September 30, 2013
File: 13105

Ms. Jean Fraser
City of Portland
389 Congress Street, 4th Floor
Portland, ME 04101

RE: 133 YORK STREET
RESPONSE TO DAVID SENUS, P.E., MEMO DATED AUGUST 27, 2013

EROSION CONTROL PLAN

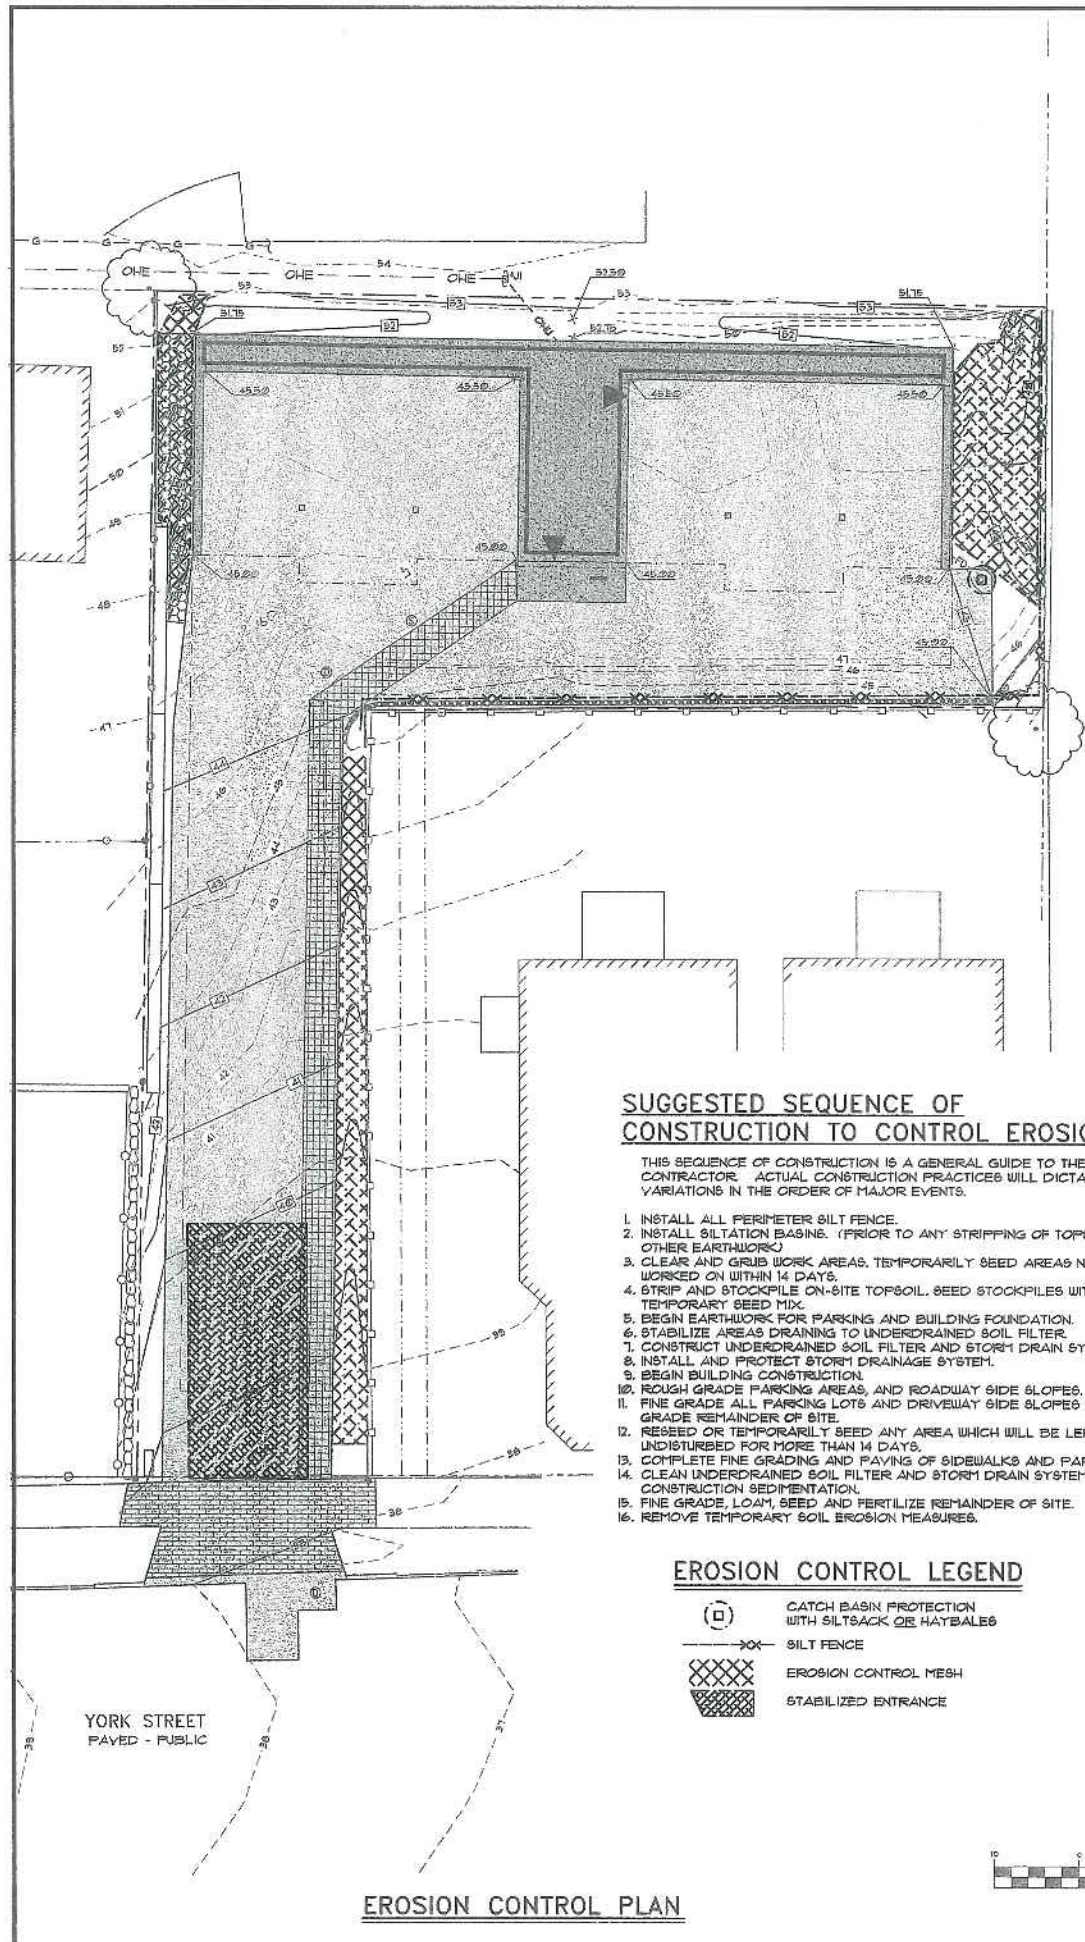
a) *Basic Standard: Plans, notes, and details have been provided to address erosion and sediment control requirements, inspection and maintenance requirements, and good housekeeping practices in general accordance with Appendix A, B, & C of Maine DEP Chapter 500. In addition to the notes and details contained on the plans, consider adding a temporary stabilization measure within the shallow swale on the east edge of the driveway.*

We have added mesh to the swale above the tree filter.
